Outline application with all matters reserved for 22 No. new dwellings consisting of 2 No. 1 bed dwellings, 18 No. 2 bed dwellings & 2 No. 3 bed dwellings.

26 Burnham Avenue Bognor Regis

Thank you for your internet representation made on 3rd April 2019 which has been recorded as '**an objection**' with the comments as follows:

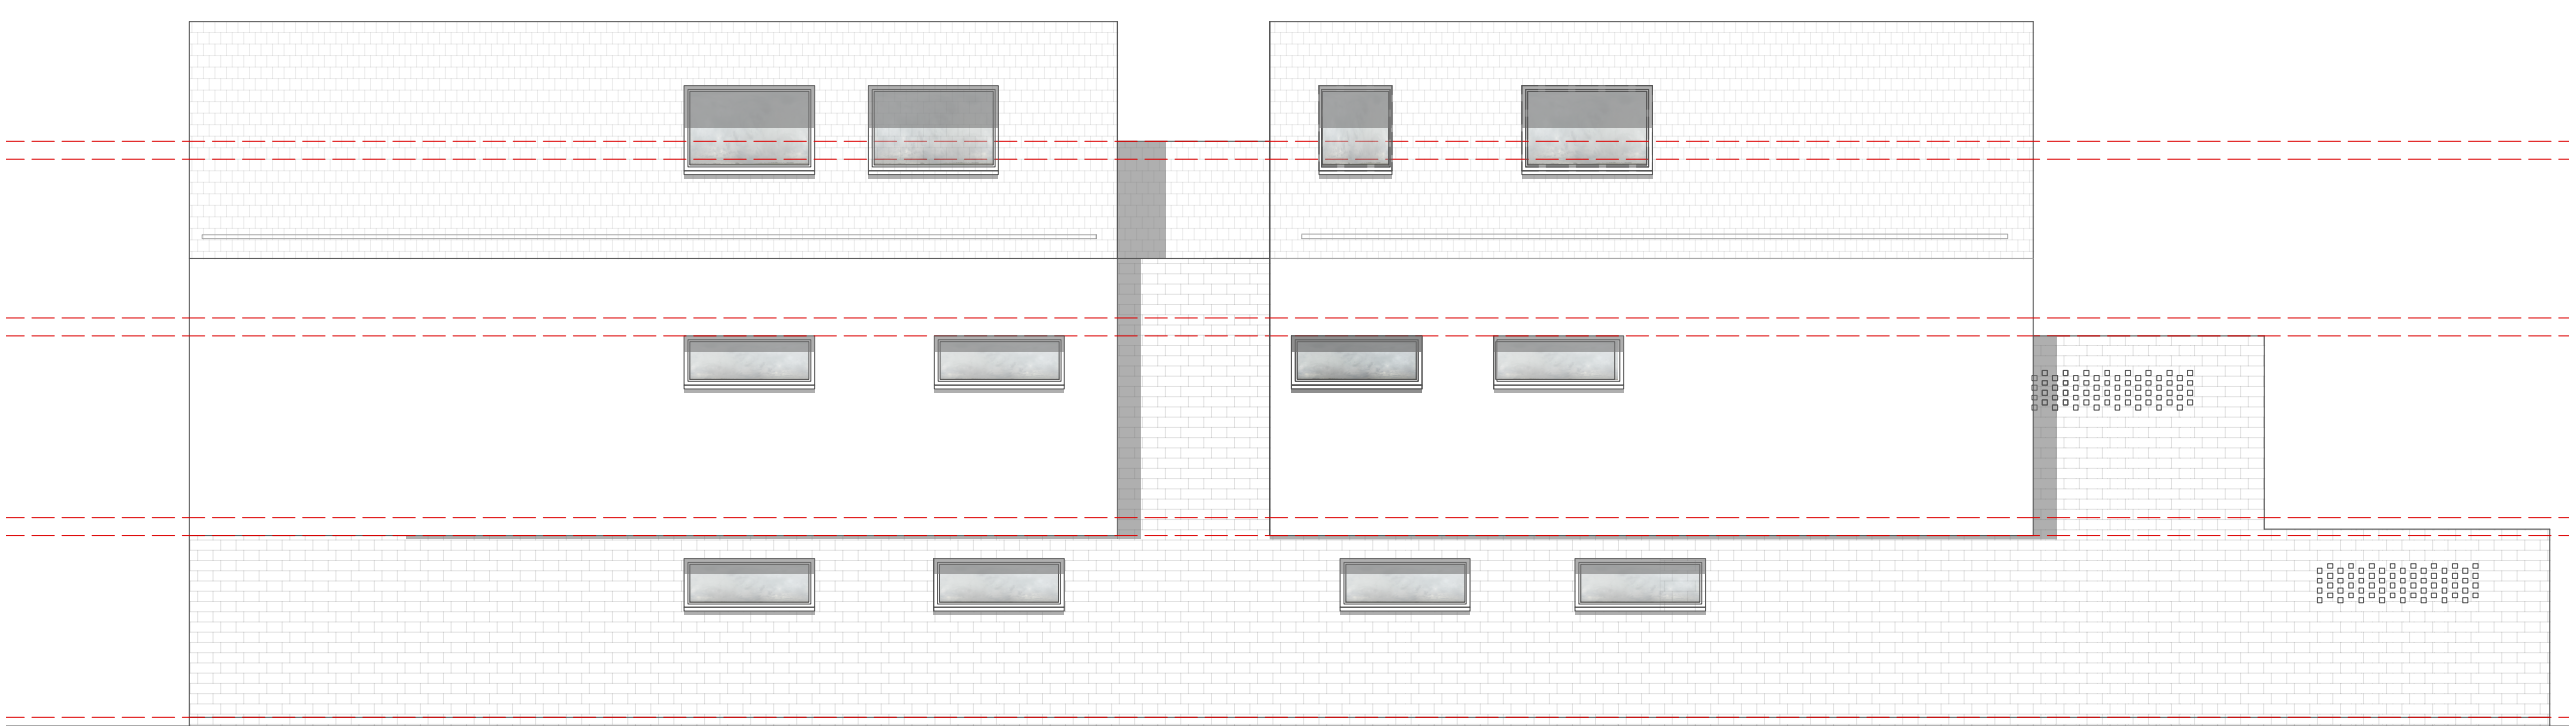
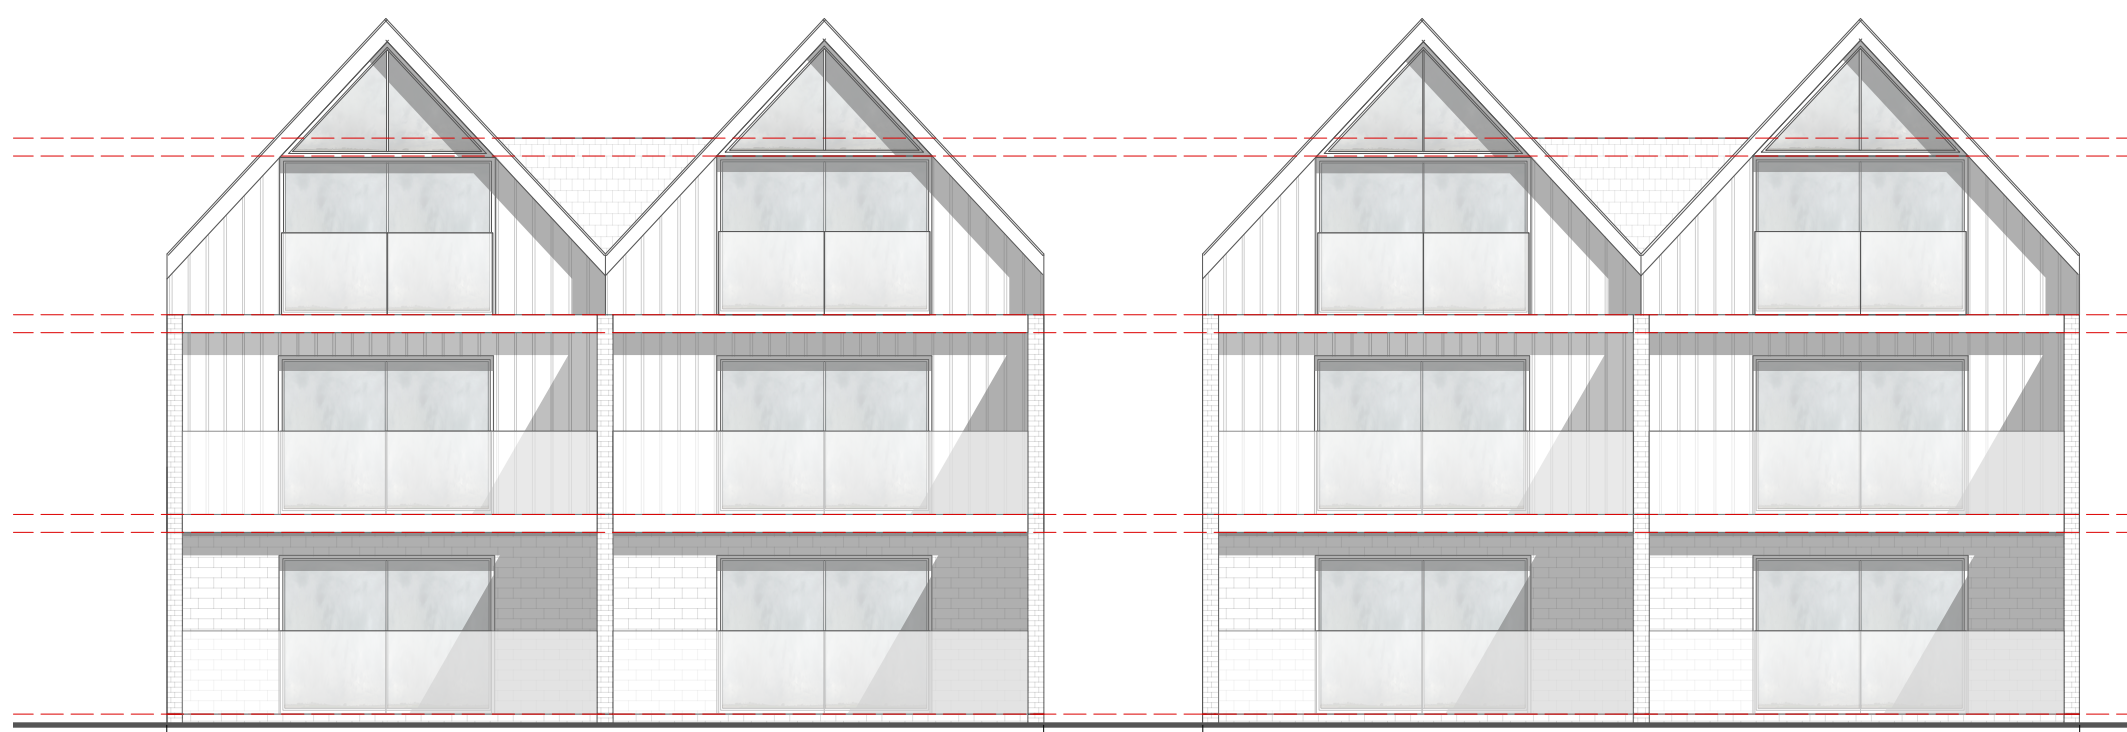
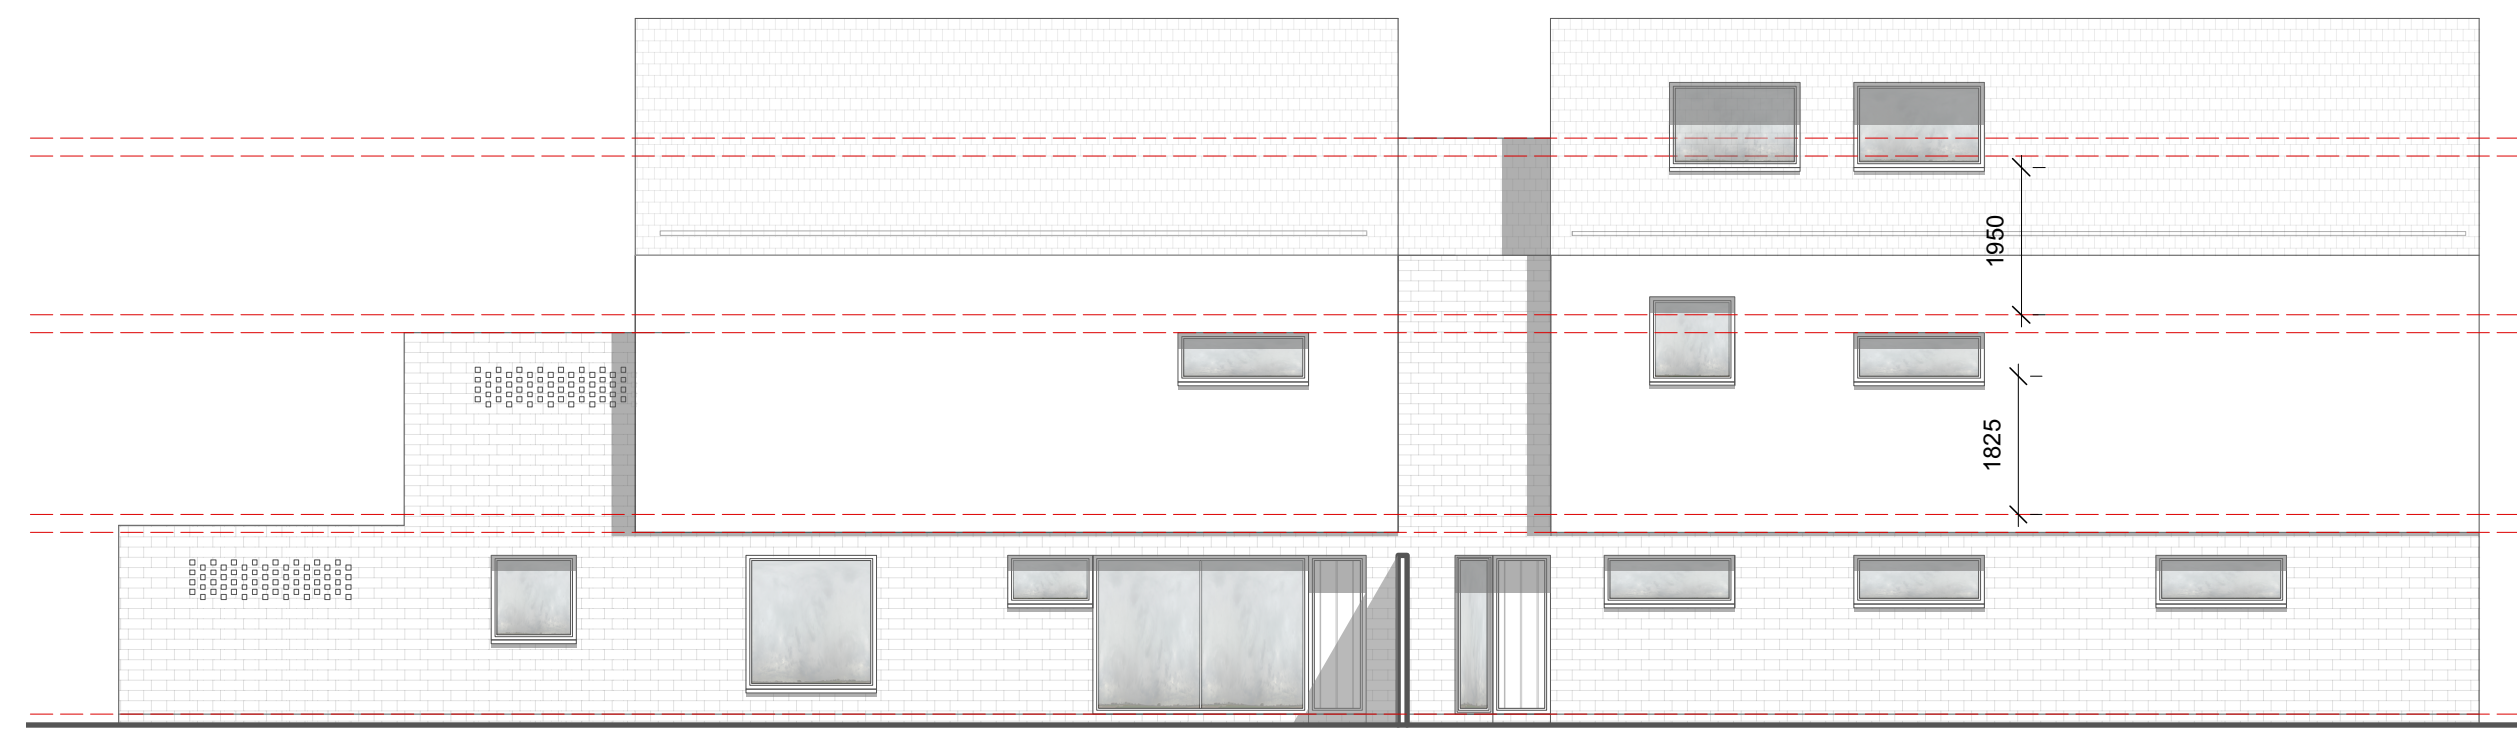
*Having seen the plans I am greatly concerned with the detrimental effect it will have on the quality of my family's lives. One block goes pretty much to the border of the grounds and will be looking straight into the windows of my property and into the bedrooms of my children. A distance of around only 12ft. The balconies that are part of the proposed design face the same way so 'textured' glass not even a possibly. The other block whilst set slightly further back will both block sun-light to, as well as have the balconies overlooking our garden. It will be a gross invasion of our privacy.*
